Rosefield Solar Farm

Applicant's Response to PFL/TCS Deadline 5 Submission

EN010158/APP/8.43
Deadline 6
August 2026
Rosefield Energyfarm Limited

PROPOSED ACCESS JUNCTION VISIBILITY SPYLA
SCALE 1:1000

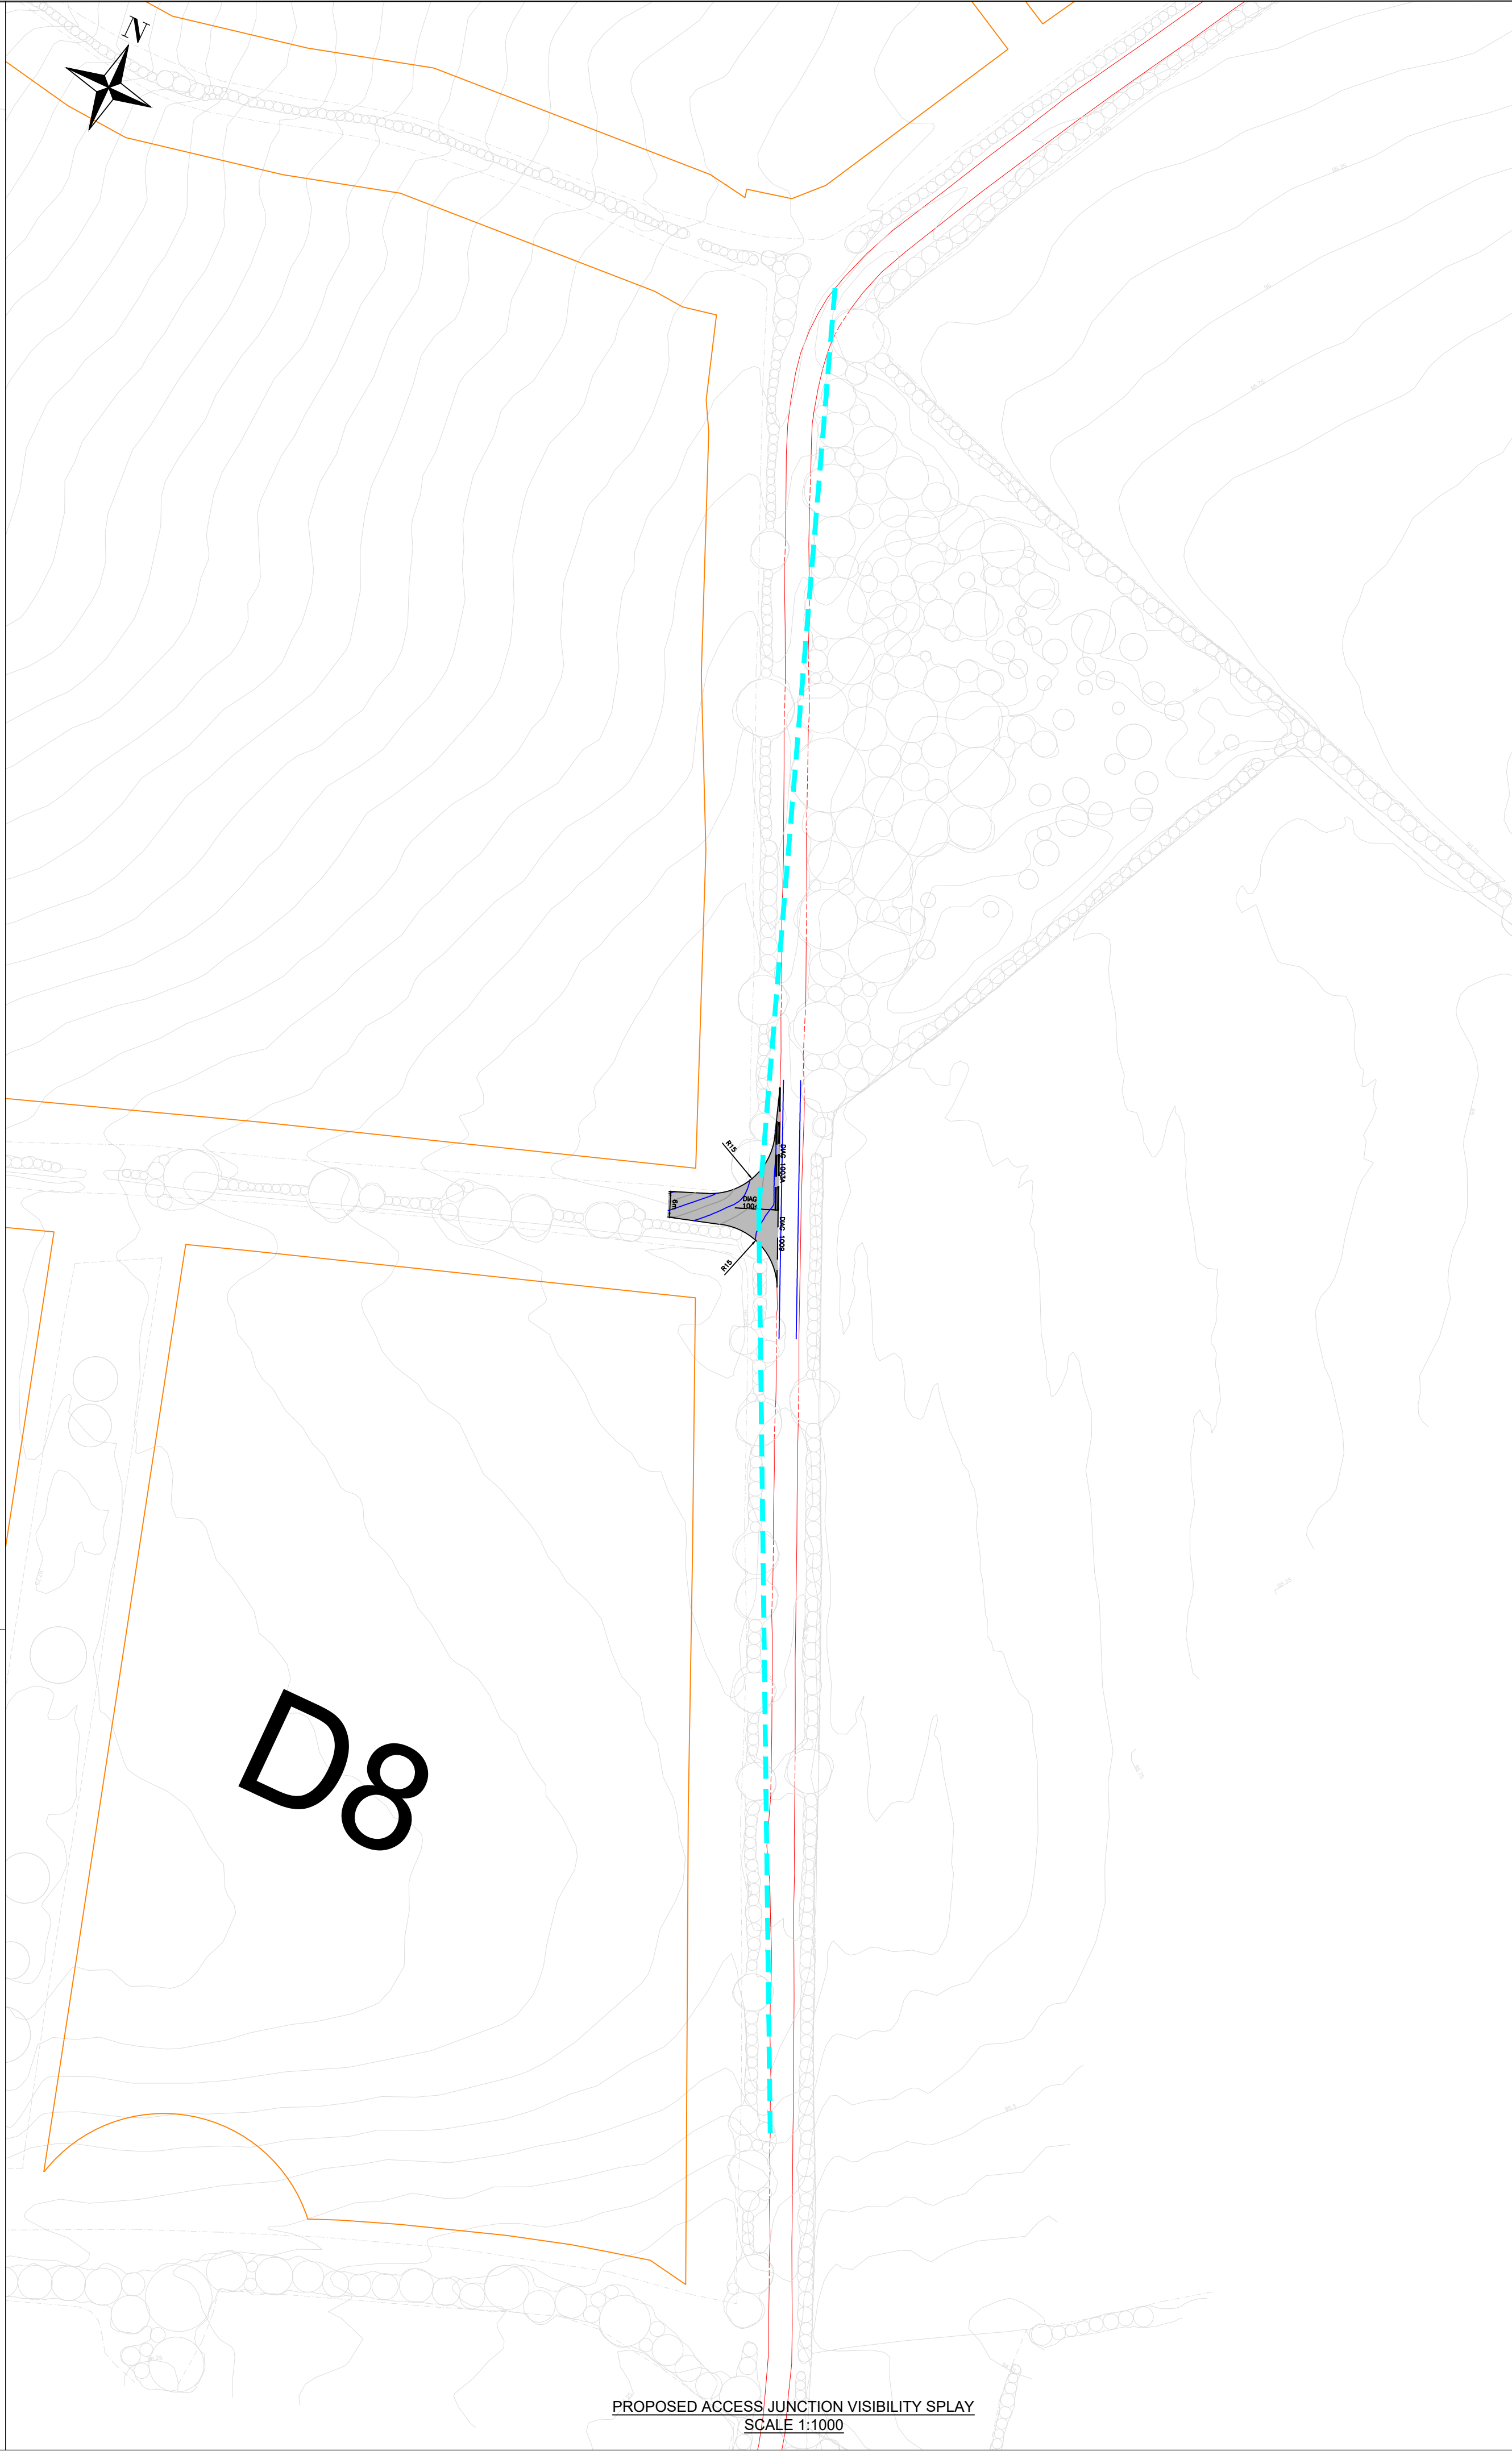
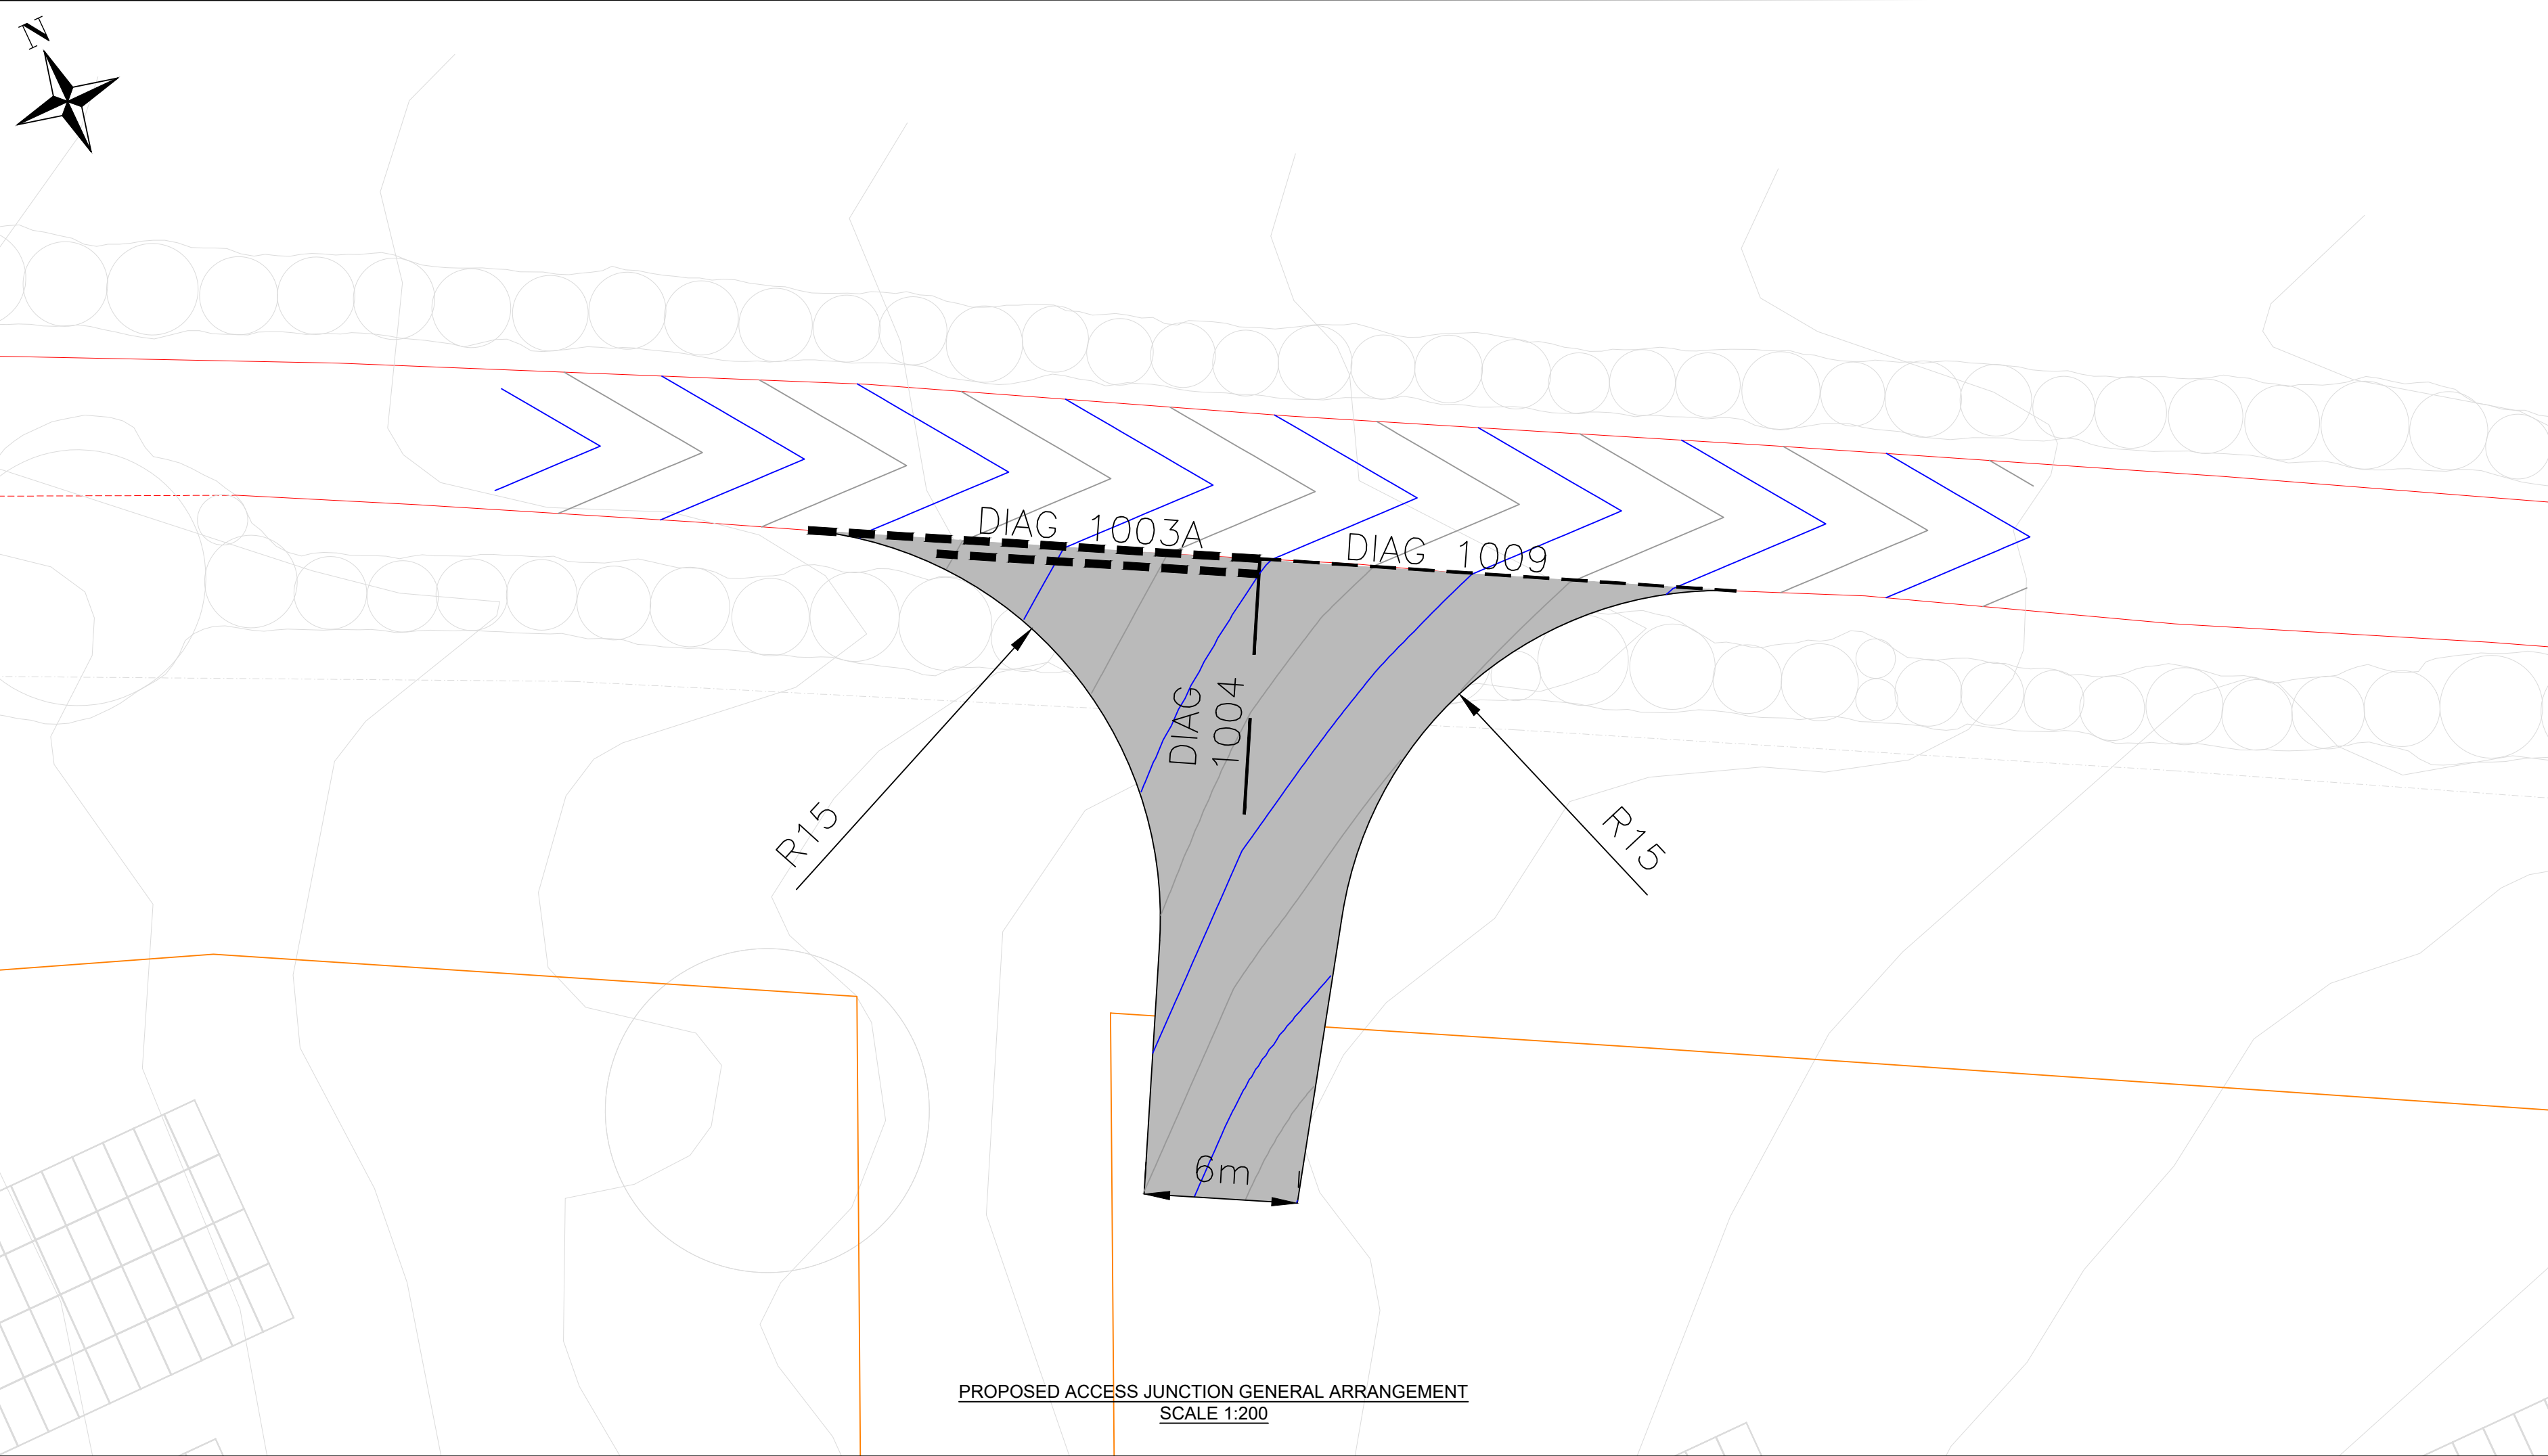
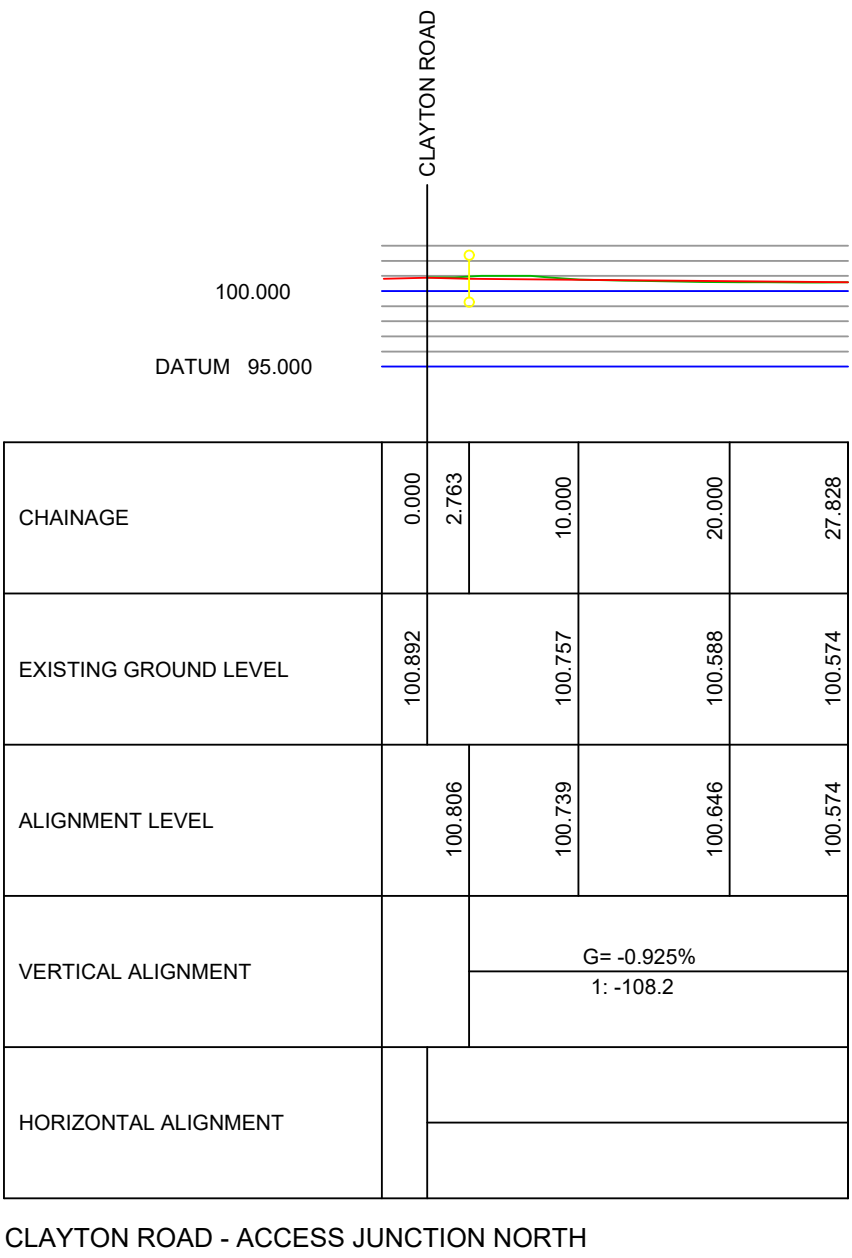
- 3.2.5. The proposed access junction layout on East Claydon Road is commented upon. The visibility splay figure is 4.5m, not 4.8m - a figure set in all design guidance and one the Railton Report author will be well aware of. The visibility splay clearly shows tree loss and it is noted that the PFL/TCS consultant provides no drawings of their own to demonstrate their points, they simply estimate, rather than provide facts.
